February 13, 2012

Project: Horse Canyon Conditional Use Permit (CU-11 -00004)

Stream

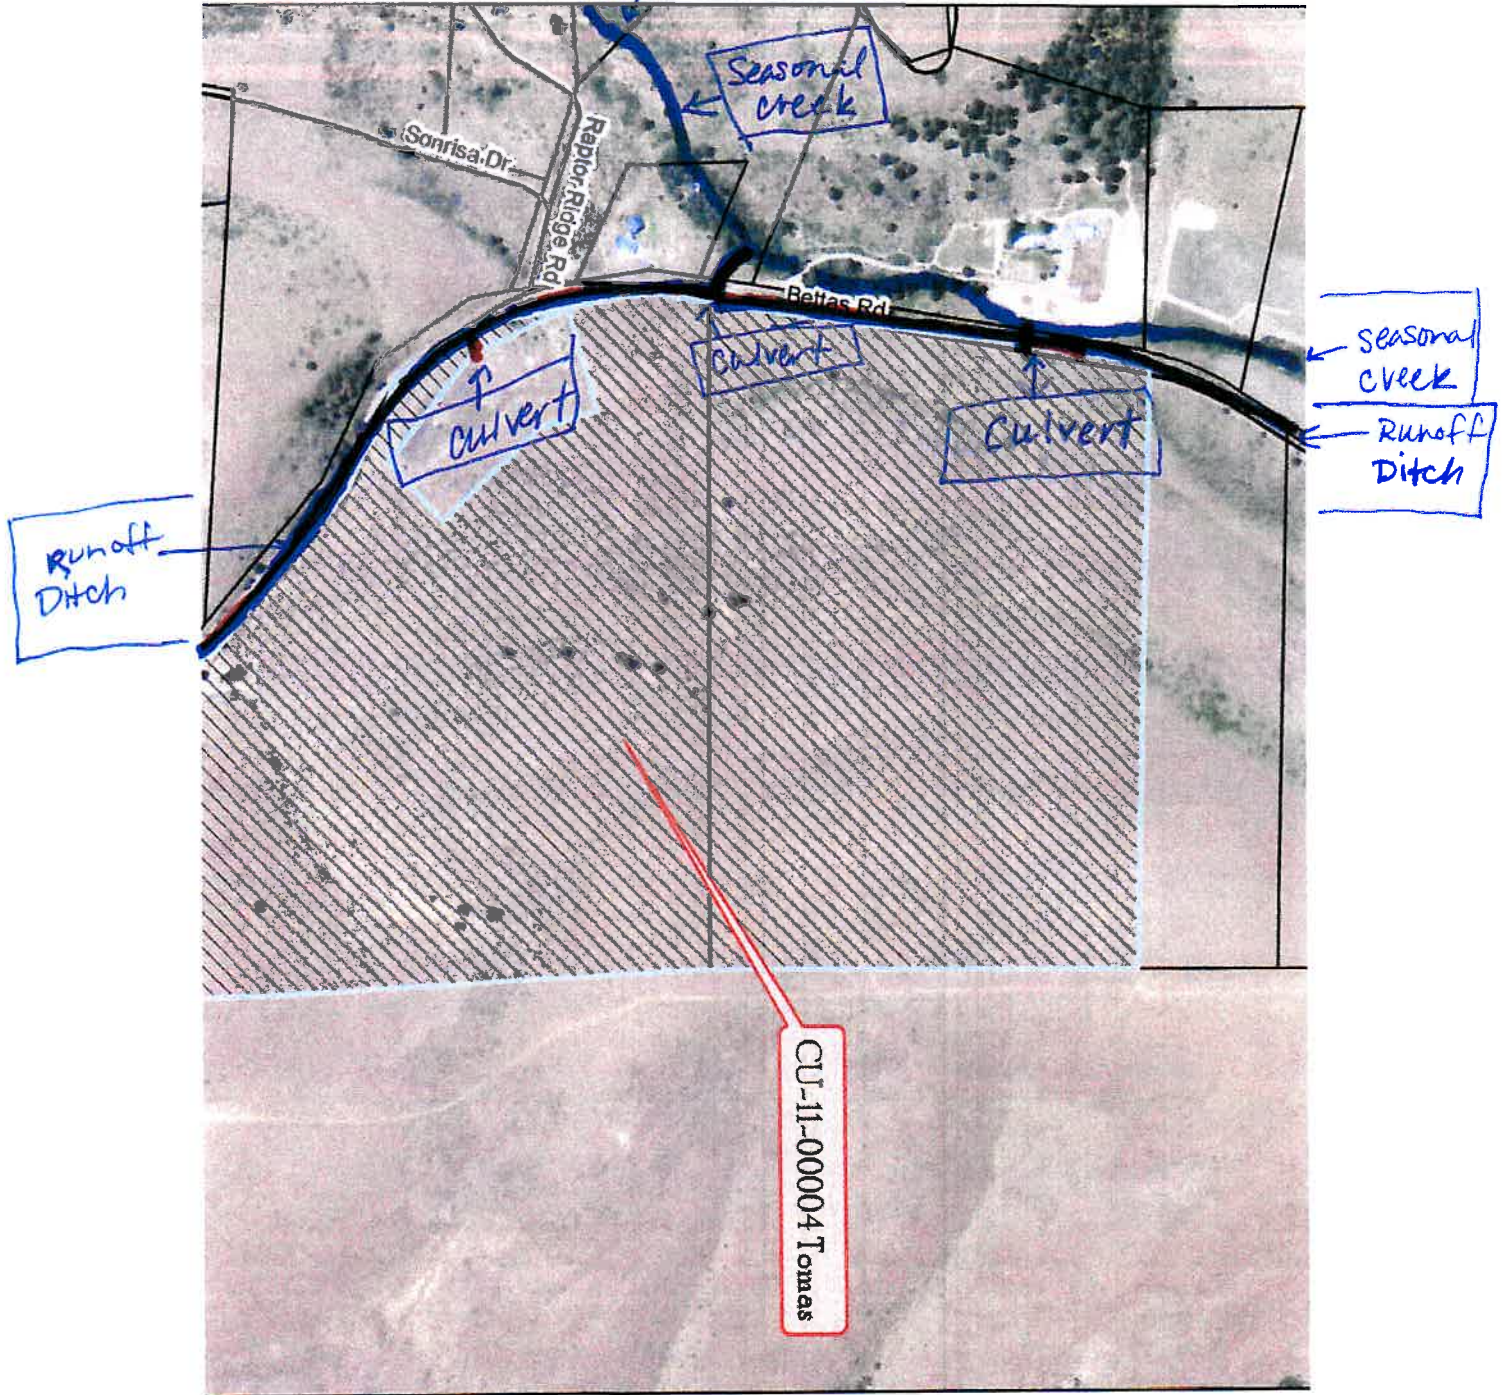
Environmental Elements Section 3 Water a 1. The SEPA checklist addresses seasonal streams. ECP mentions a spring fed pond that the adjacent owner has rights to. There is a seasonal stream within 100’ of the site. The ditch that follows Bettas Road runs along the western boundary of the proposed site and feeds into the stream through two culverts. ECP made no mention of this stream on the SEPA checklist, a stream that flows into Swauk creek and eventually into the Yakima River. None of the maps ECP submitted track the streams flow.
